Subject: RE: [EXTERNAL] Fwd: Site 6, Chichester Road, Bersted ref BE/84/19/PL

Status
for planning
Scale
1:200@A1
Job number
1526
Drawn
AR
Drawing number
L90-201
Date
Aug 2019
Revision
A

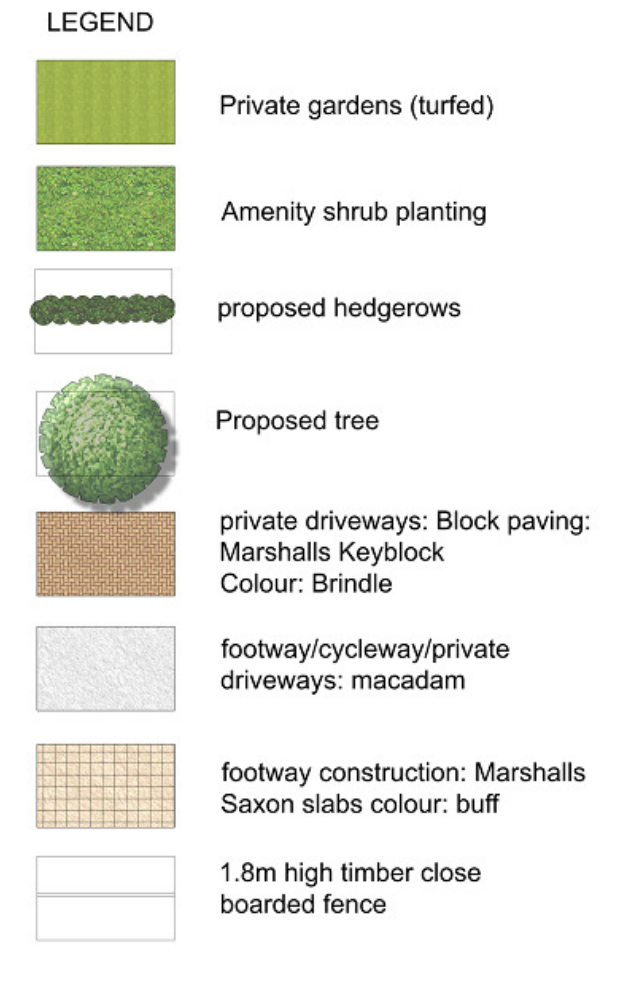
I have been looking at the hedge on Google Streetview (dated to June 2018) and this clearly suggests that the hedge is wider than the 2m width shown on your landscape plan. I estimate (using a brick length of 22.5cm) that the section above the brick wall in the attached photo is around 2.25m. The image suggests the hedge is at least double this. Also, I note that the streetview imagery suggests that the hedge is not a perfect straight line as per your drawing.
